From: Simon Davis
Sent: 20 December 2021 12:58
To: 'Andrew Prentis' [REDACTED]
Subject: RE: Planning application P/157/21/PL at 31 Lagoon Road, Pagham,

Dear Mr Higham

Thank you for your letter of 7th December.

PROJECT TITLE: 31 Lagoon road
DRAWING TITLE: Street Scene
DRAWING TYPE: Proposed
DRAWING NUMBER: B_300
SCALE: 1:200 @ A3
DATE: NOV '21

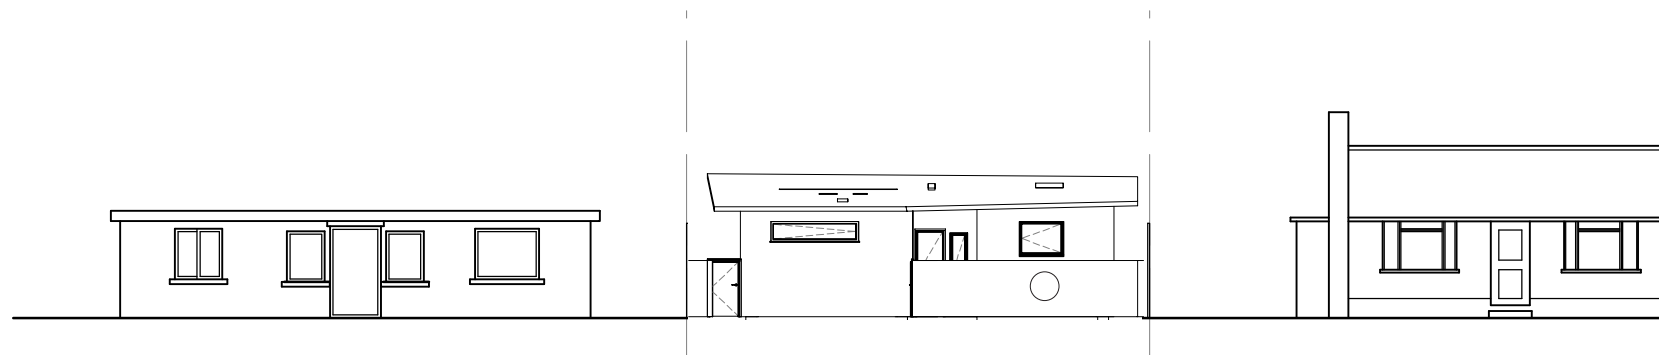
4. The building will be Approved Document B compliant in accordance with UK law.
5. There will space for 2 cars to park.
6. The information you are looking for is on the drawing entitled 'Street Scene'.

02. Roof Plan

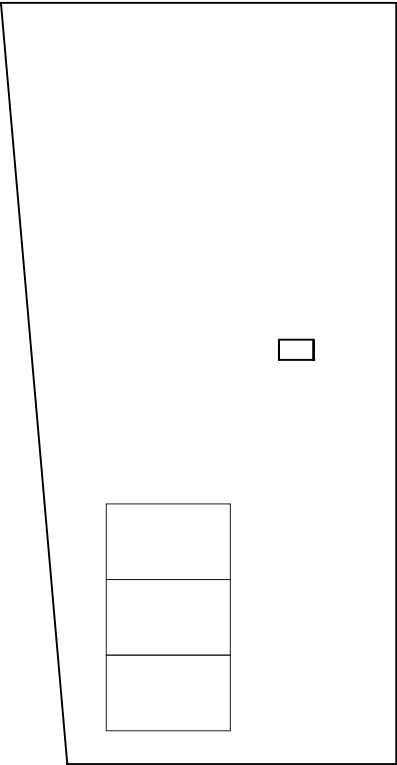
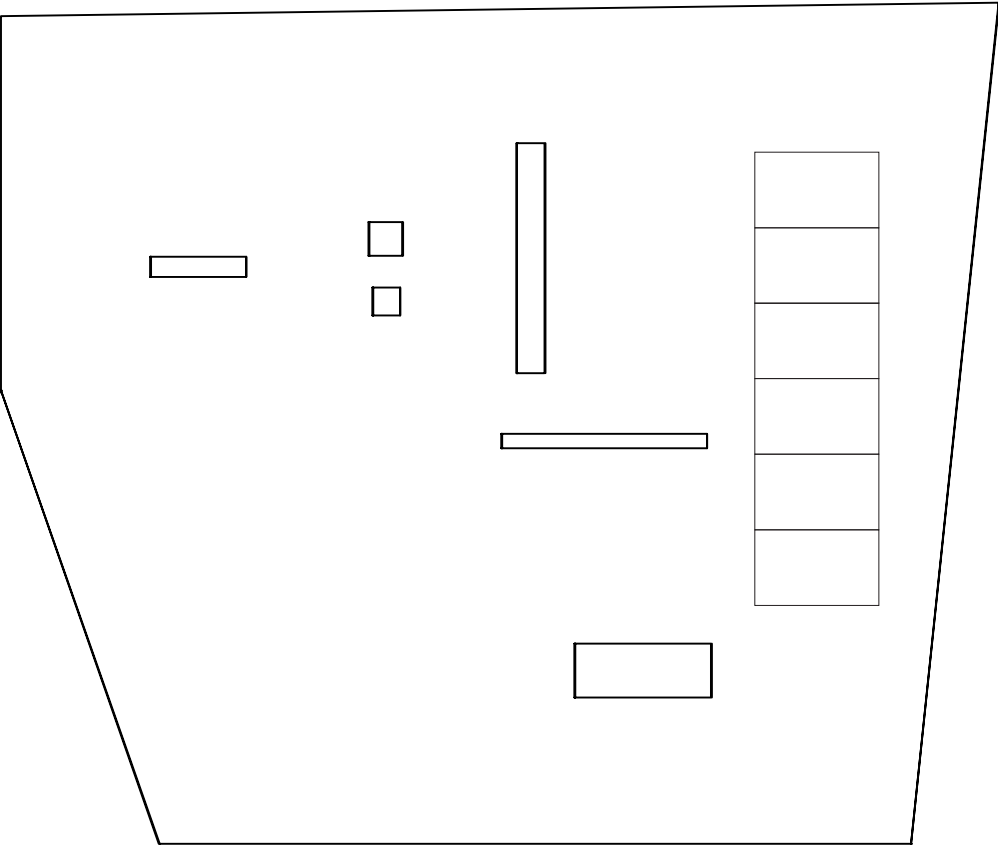
3. Updated roof plans differentiating between roof lights and solar panels have been submitted as well as an updated floor plan to show the position of the roof lights.
